5 April 2019
Our Ref SU7340
Your Ref: SDD8699

**Redevelopment of Greenwich Hospital (Concept Proposal) at 97-115 River Road
Greenwich (SSD8699)**

I refer to your Notice of Exhibition dated 11 February 2019 and accompanying two volumes of the Environmental Impact Statement (EIS) in relation to a Development Application for the Redevelopment of Greenwich Hospital (Concept Proposal) (SSD8699).

DRAWING TITLE:
MID WINTER SHADOWS AT SOUTHERN
BOUNDARY - MORNING
DATE:
AUGUST 2019
DRAWN:
EC
PROJ:
1213
PROJ ARCH:
BF
DRAWING:
S.48
SCALE:
1:1000 @ A1
REVISION:
P5

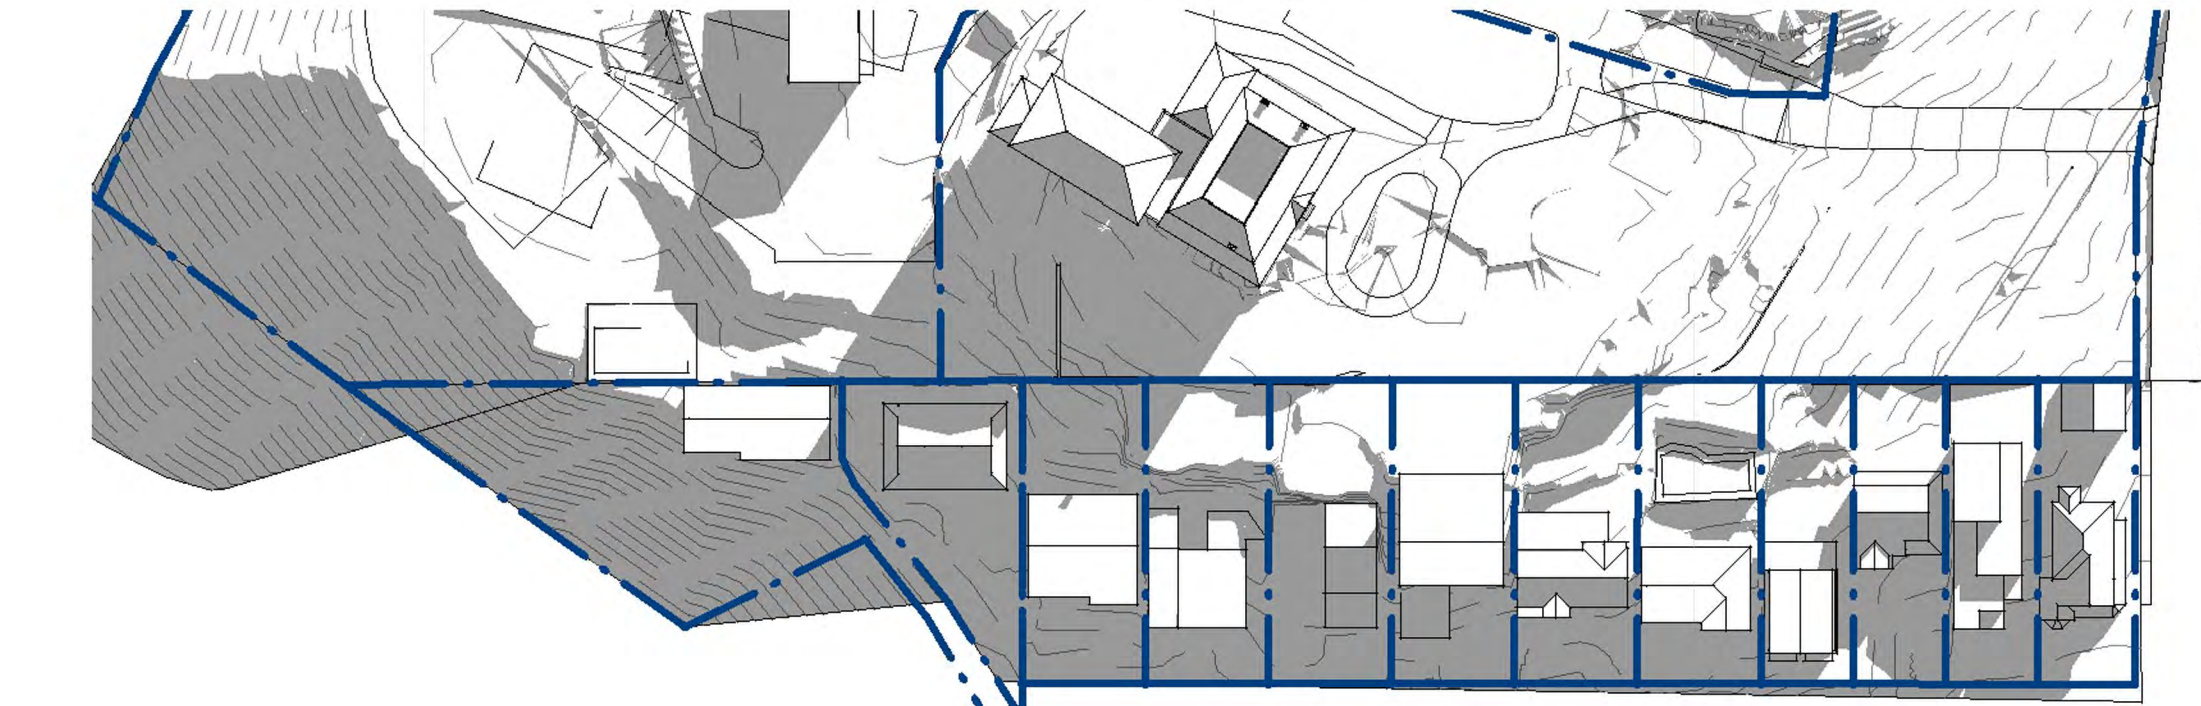
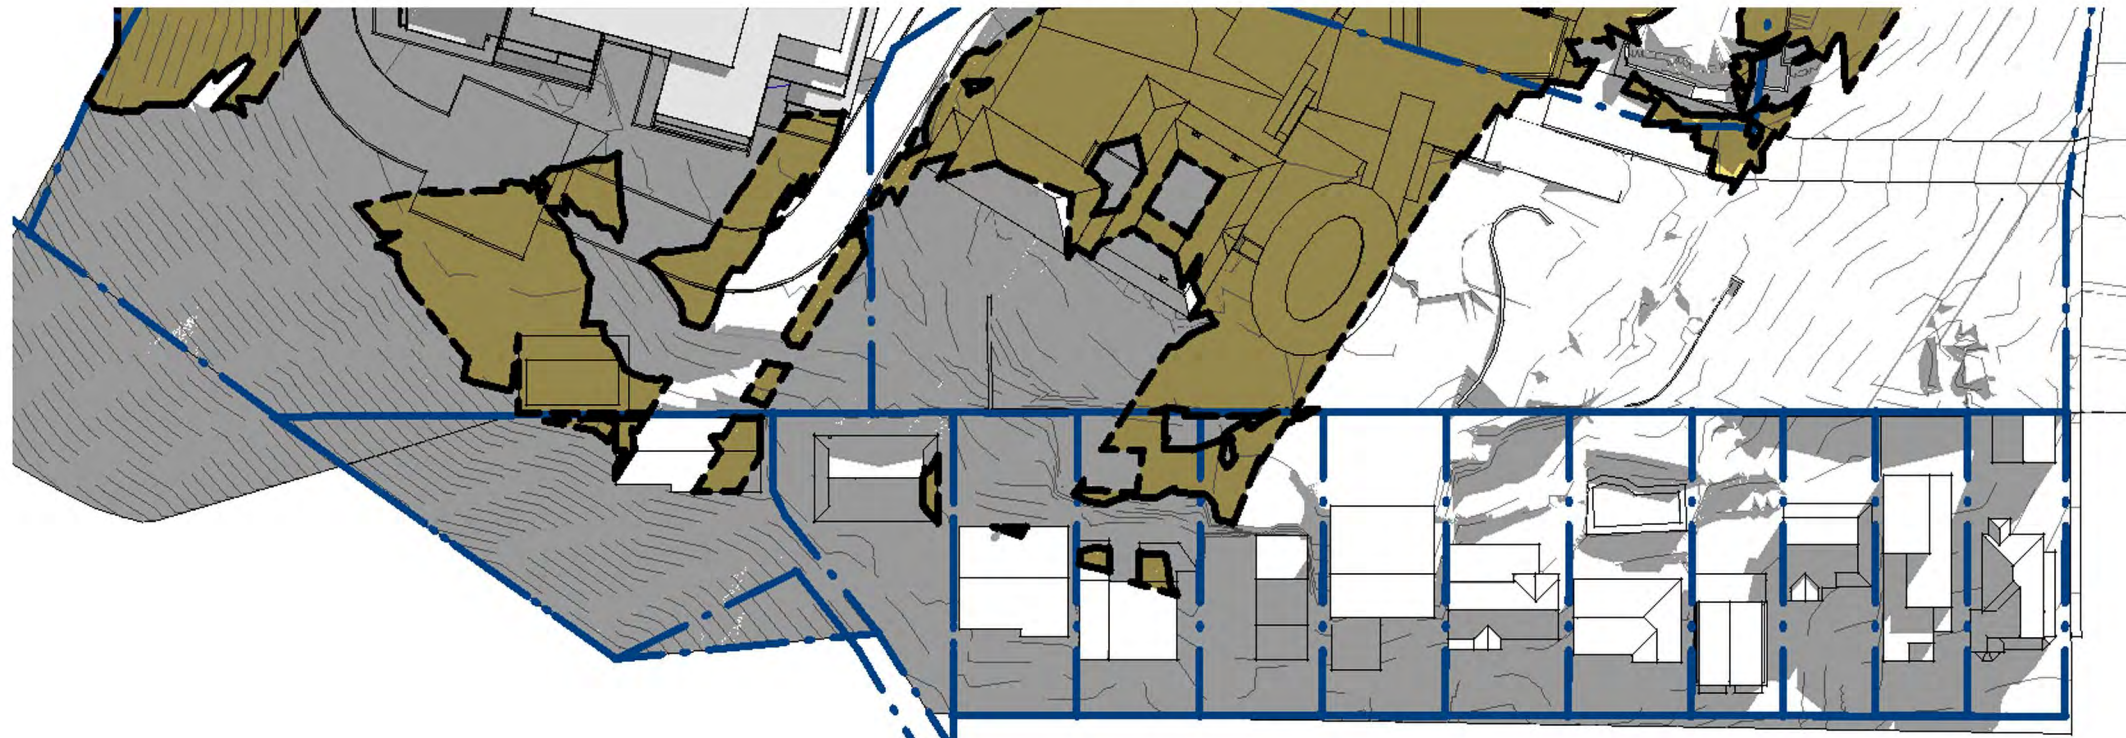
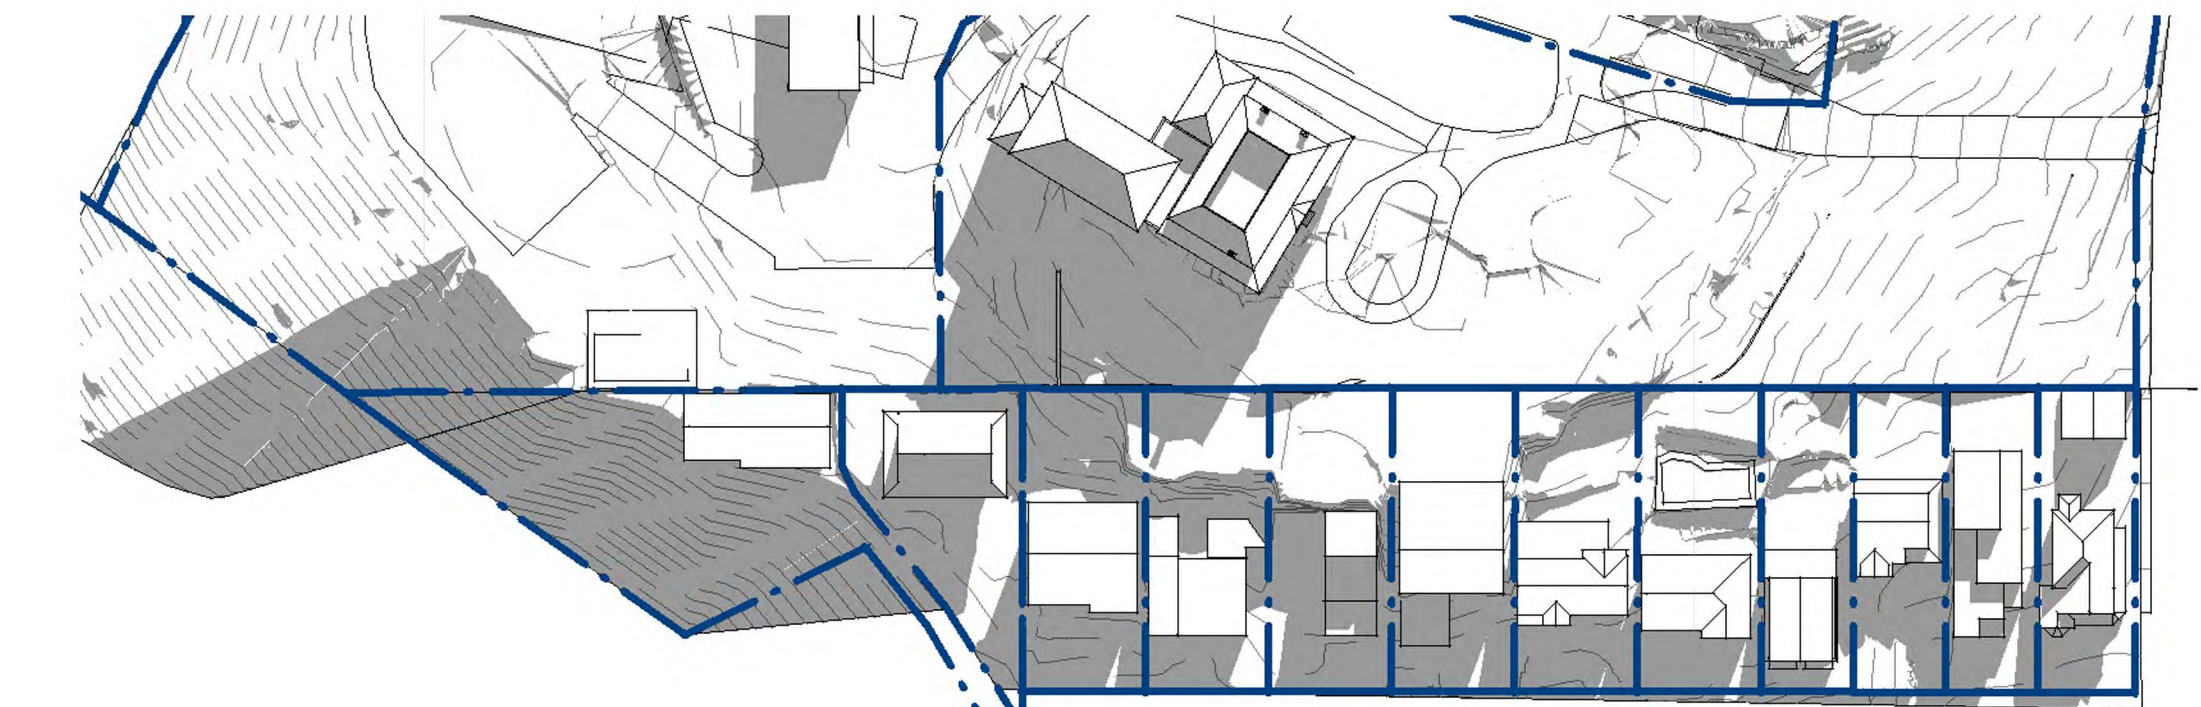
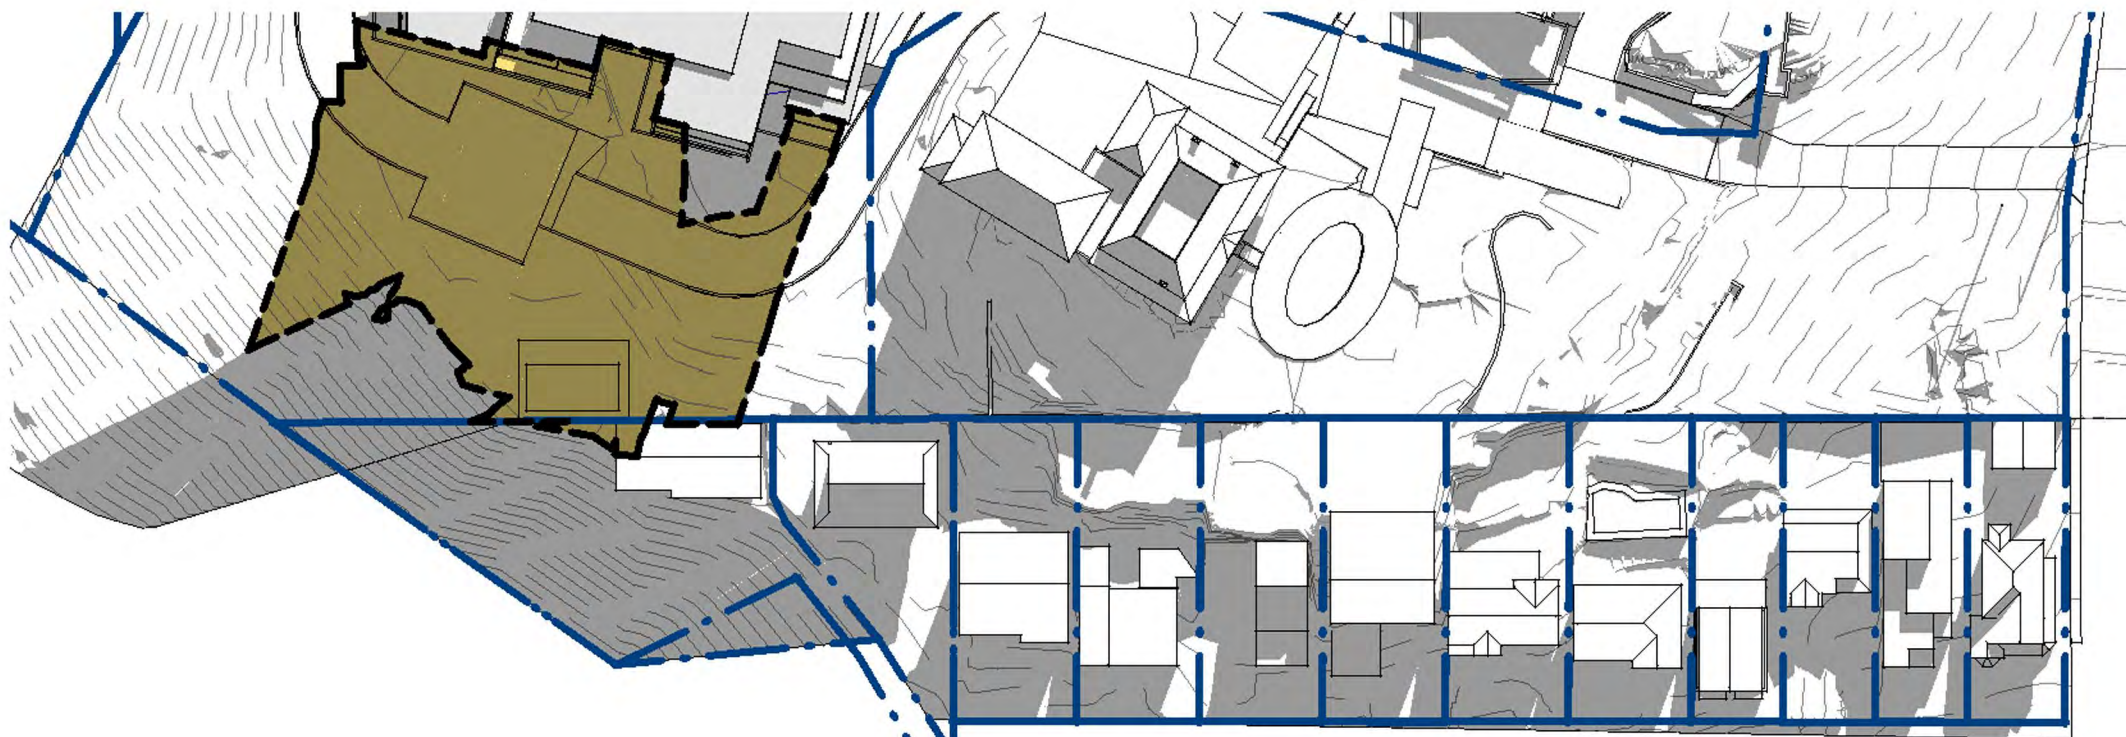
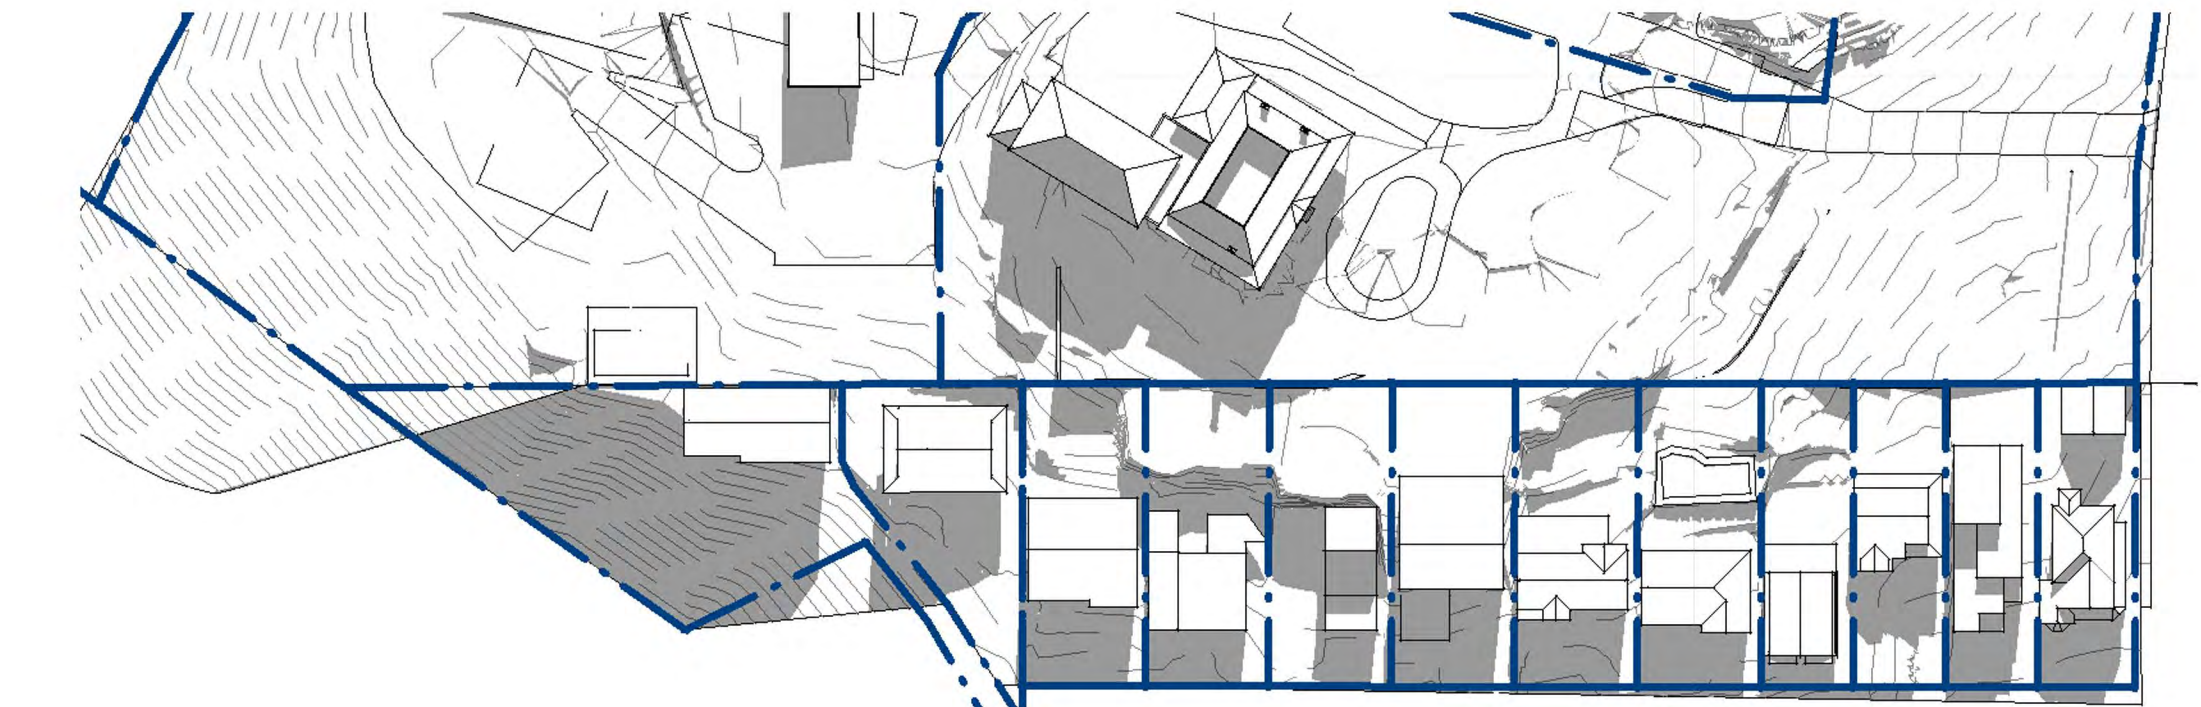
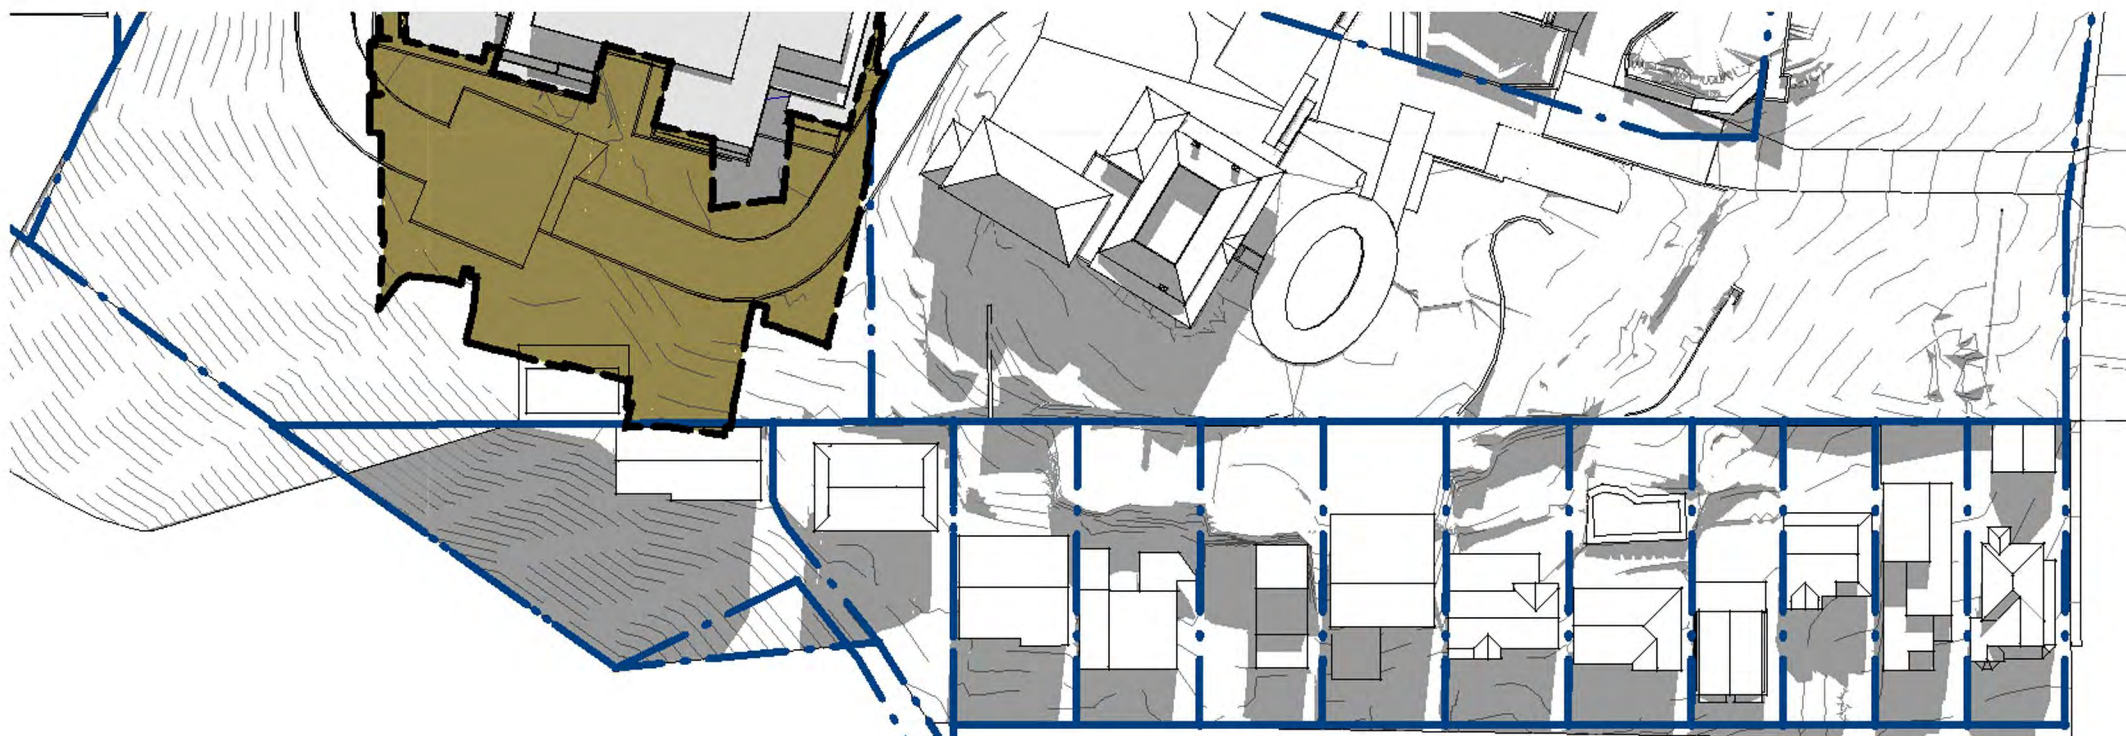
The proposal indicates an increase in shadows south west of the site at 9.00am during mid-winter. The DCP recommends new buildings and structures to be designed and orientated to ensure reasonable sun access is maintained to adjoining bushland throughout the year.
